**Addendum No. 1**

RE: Contract # C204525  
WBS # 2021CPT.05.03.20921.1  
STATE FUNDED  
**Wake County**  
78 SECTIONS OF SECONDARY ROADS.

**October 20, 2020 Letting**

TYPICAL SECTION NO. 4

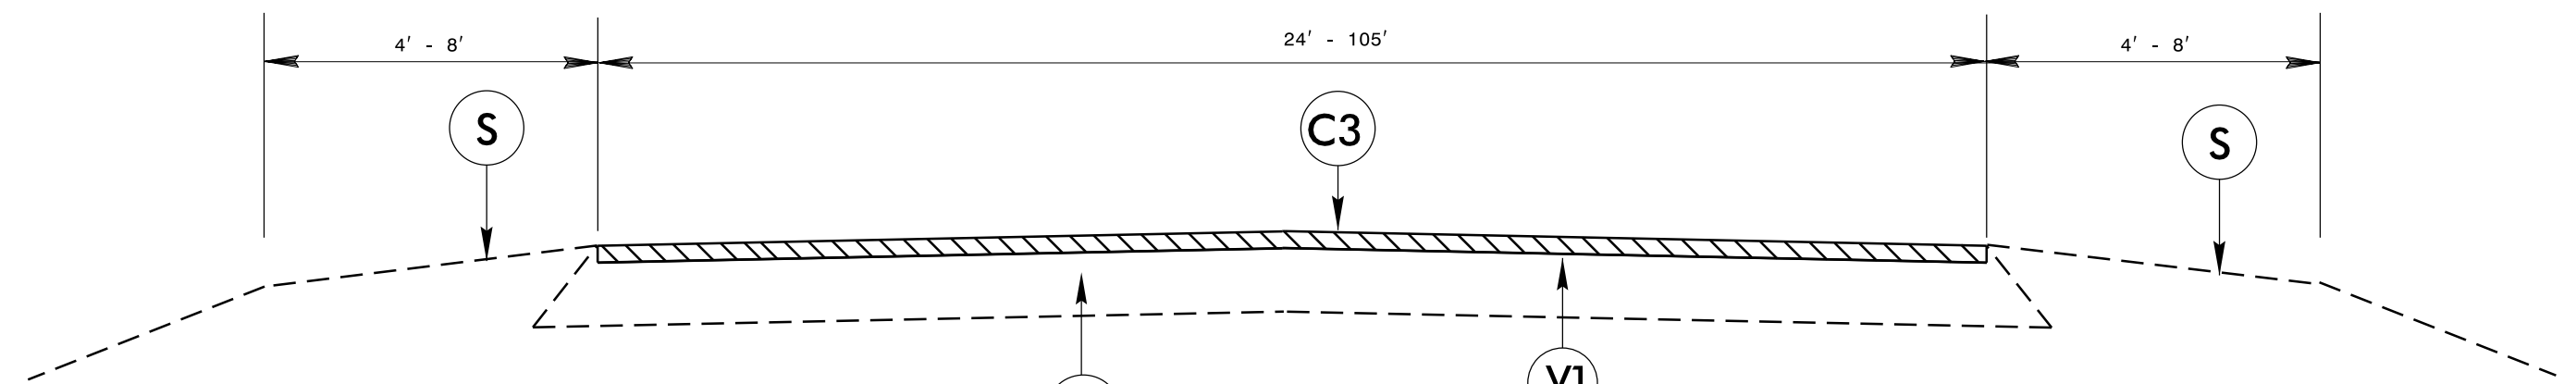
Sheet No.	Revision
Sheet 10	Removed 4' dimension from Typical Section No.4
